# CITY OF ALBUQUERQUE

**RE: McMahon Market Place New Shell Building  
5730 McMahon Blvd NW  
Request for 30 Day Temporary C.O. – Accepted  
Engineer's Stamp Date: 5/30/17  
Engineer's Certification Dated 04/17/18  
Hydrology File: A11D011E**

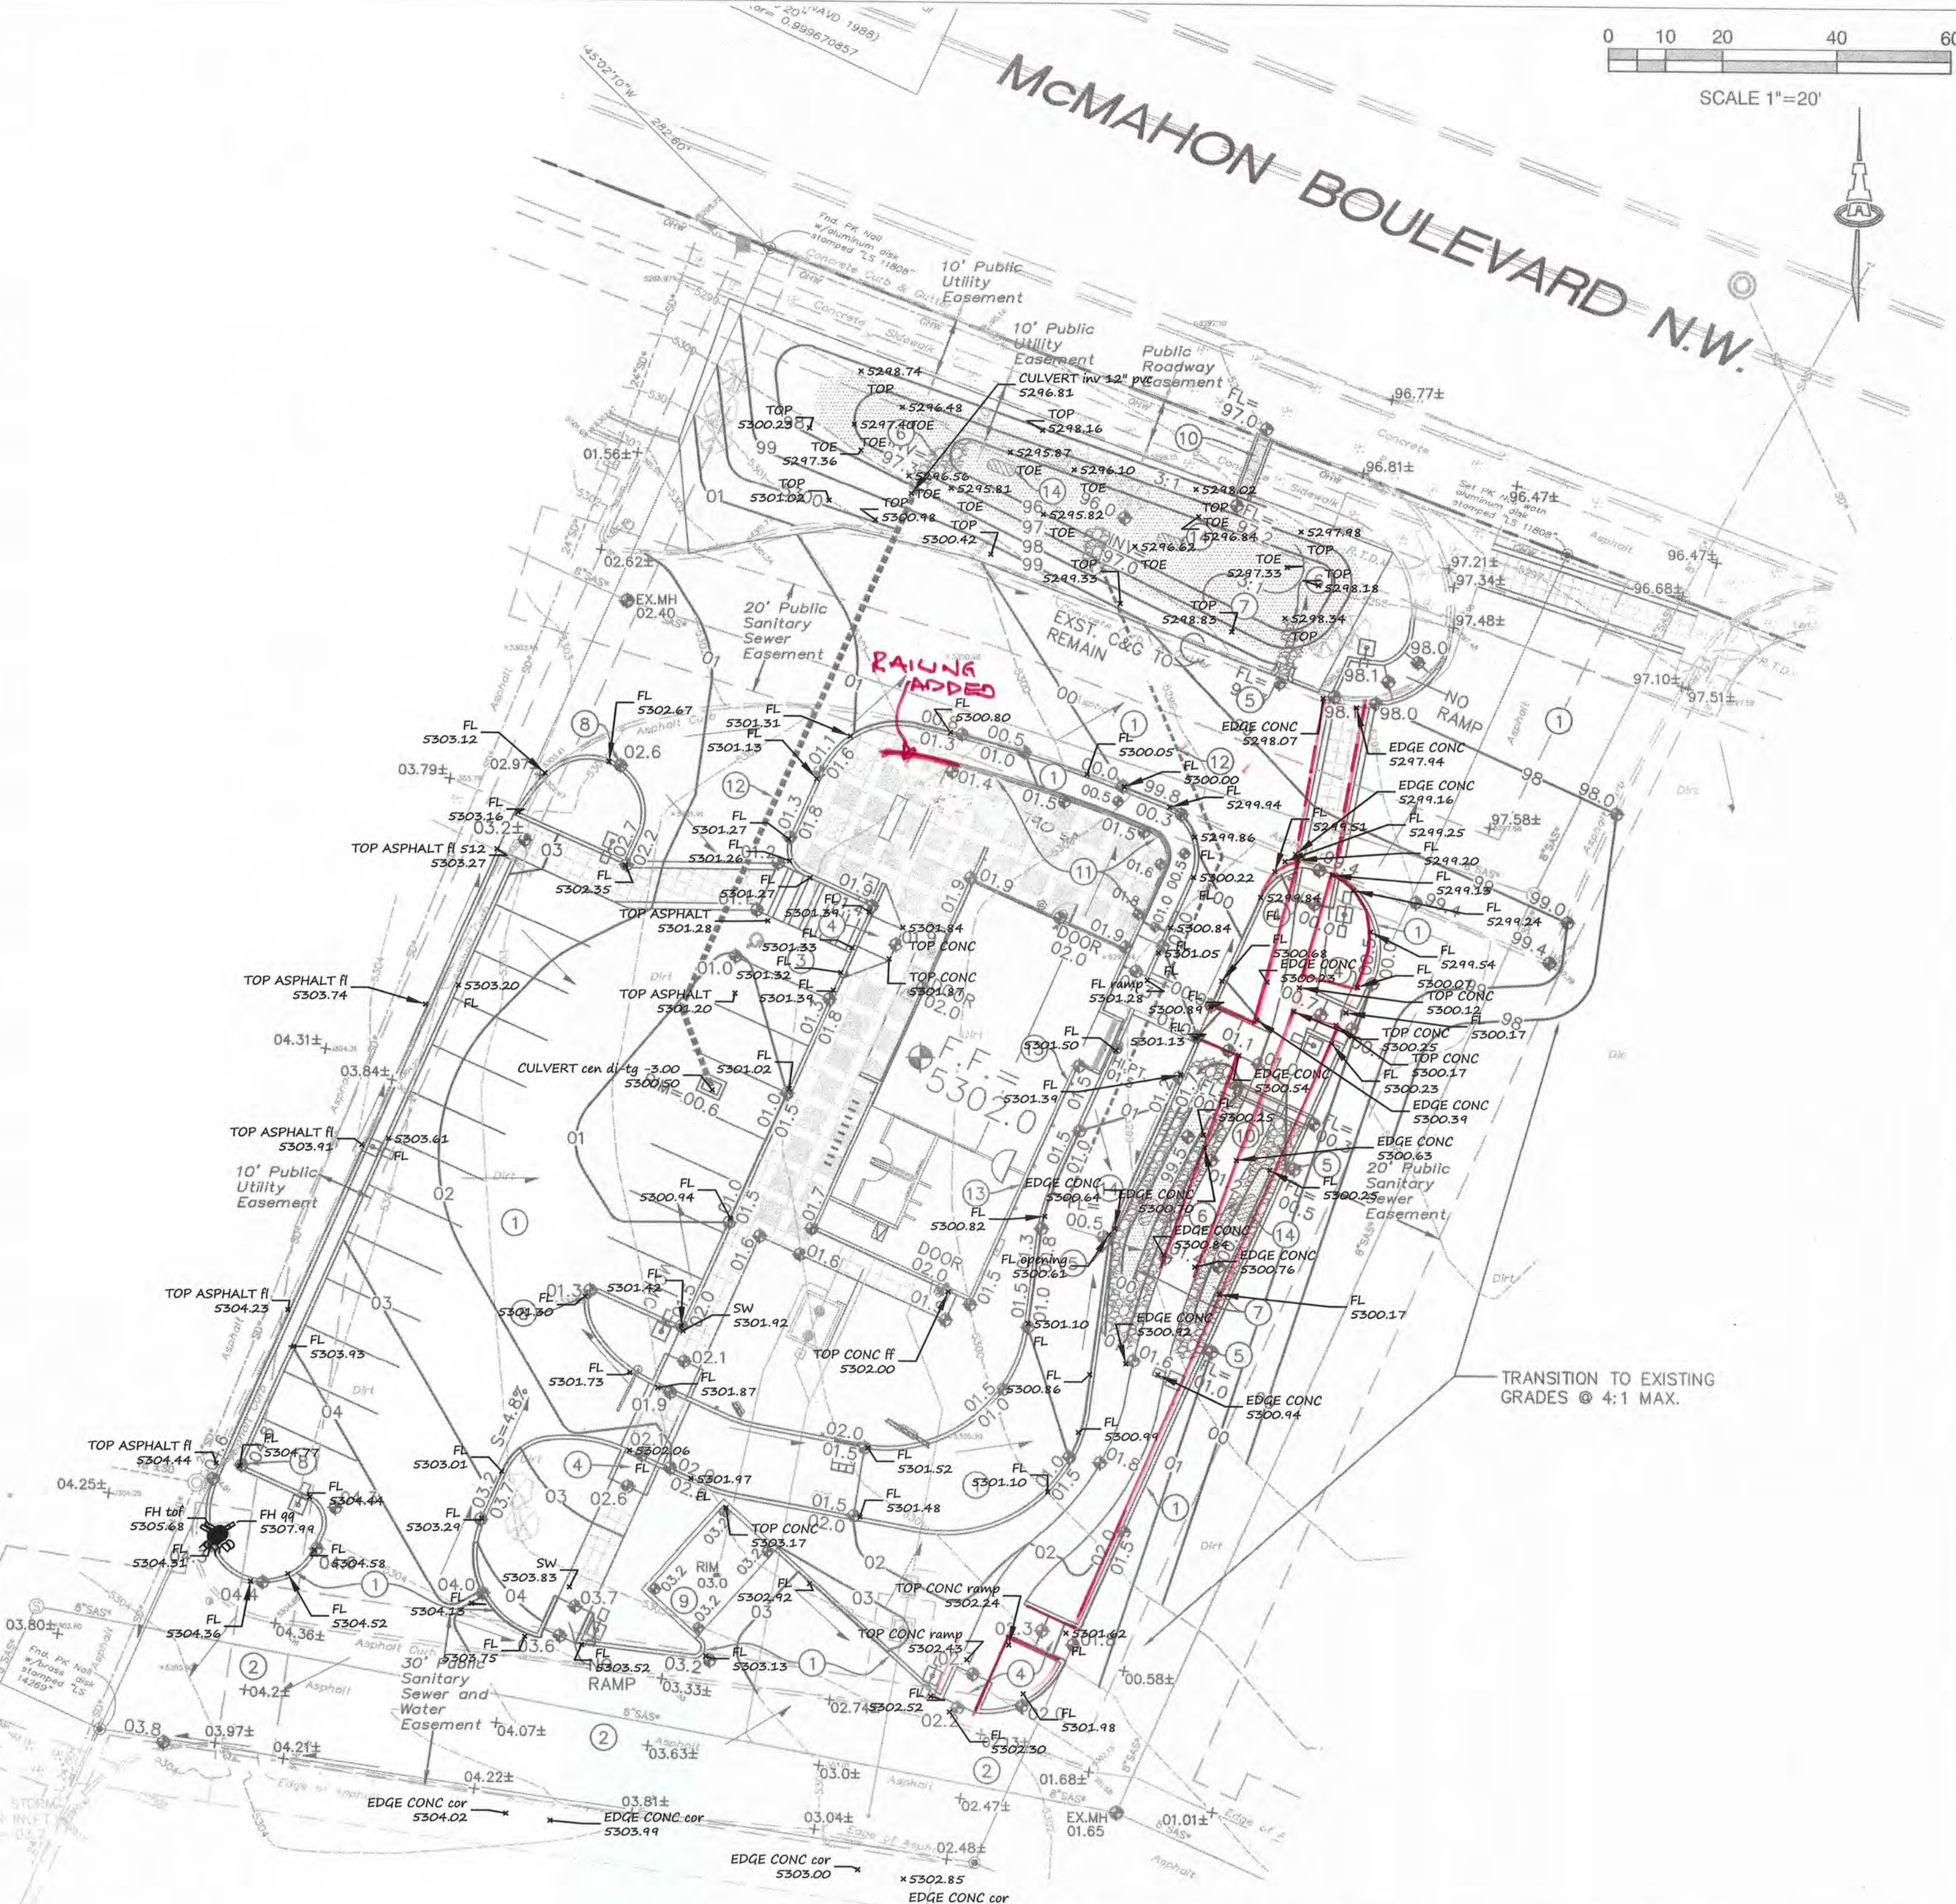
1. The sidewalk culvert needs to be accepted by Jason Rodriguez (C.O.A. Storm Maintenance). Jason needs the contractor to extend the steel plat to the face of the curb on McMahon and bolt the plate down. The contractor can contact Jason at 505-857-8607 or his Cell at 505-235-8016.
